CITY OF ALBUQUERQUE

PLANNING DEPARTMENT – Development Review Services

February 3, 2015

**RE: Los Diamantes Subdivision
Drainage Report, and Grading and Drainage Plan
Engineer's Stamp Date 1-13-2015 (File: N09D013)**

Los Diamantes Subdivision
Drainage Management Plan

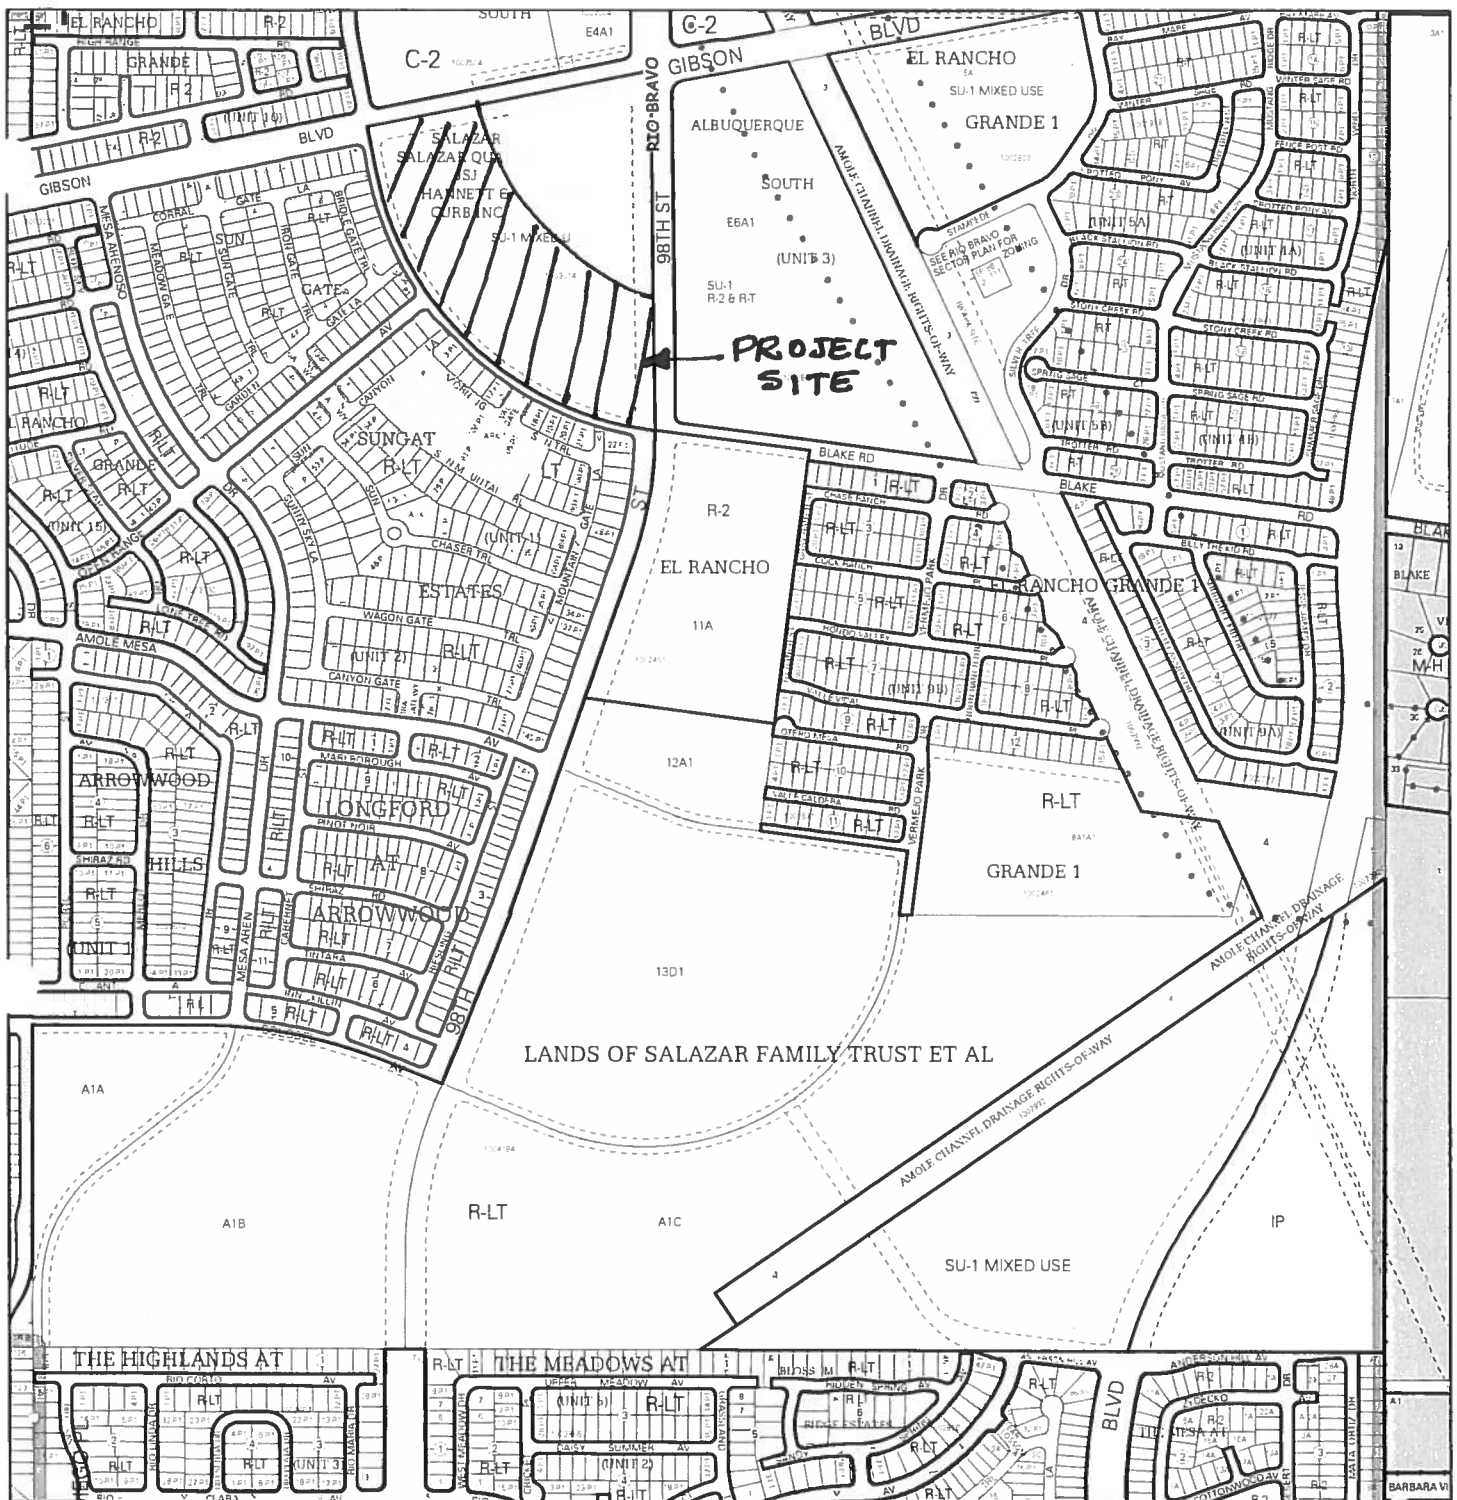
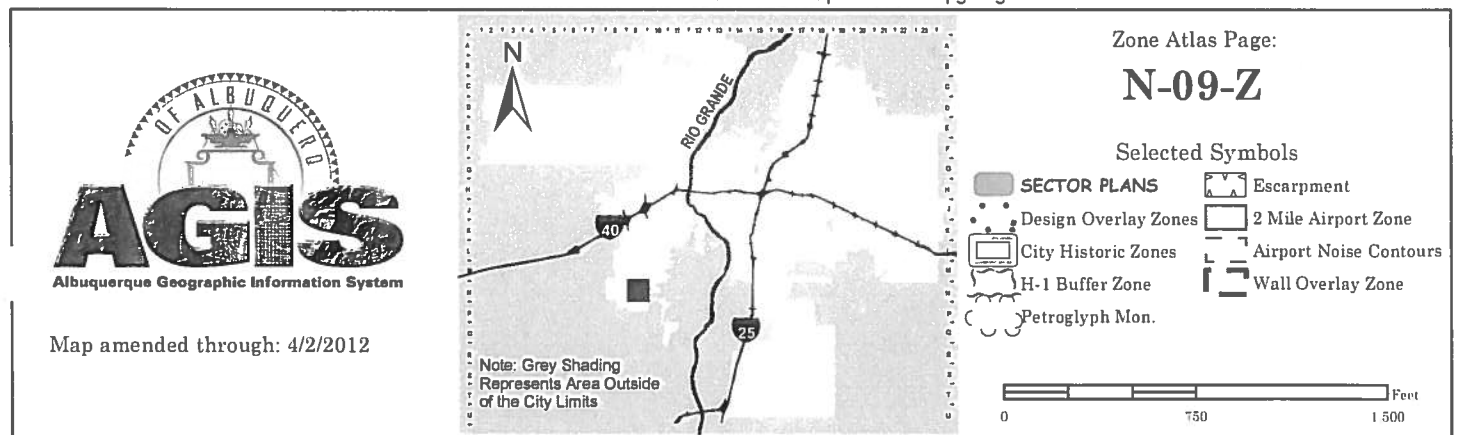
1. Provide Bench Mark information using NAVD 1988 Datum. Are the elevations shown in the new or old datum?
2. Aerial views show a pond in the NW corner and a channel further south that are not reflected by the existing contours. Are the contours from a historic LIDAR? Google map views show that this site is lower than 98th Street and Blake, but this is not reflected in the contours and flow line elevations. Do you have a current survey? Show Flowline elevations of Gibson, Blake and 98th St.

3. Tract A presently drains through the proposed development. How is Tract A proposed to drain in the interim and future conditions. Since there is no storm drain in 98th street, will Tract A also be discharging to the detention pond?

4. What is the meaning of the hatched line within the pond? It is not on the legend, but appears to be some sort of wall.
5. The outfall structure is 8.5' in diameter that discharges to a 30" SD. For safety reasons, it is preferred to provide a stand pipe/riser, with the top open for emergency overflow.

6. Show Volume and emergency overflow for the detention pond.
7. As-built Shows 30" stub out Inv.= 5097.17, rather than 5099.12 as shown on the Grading plan.

8. How will flows discharge into the pond?
9. Provide Basin Boundary map showing peak flow rate from each basin.
10. Provide Street capacity calculations. On Basin map show the max. peak flows for both the mountable curb sections and the standard curb sections.
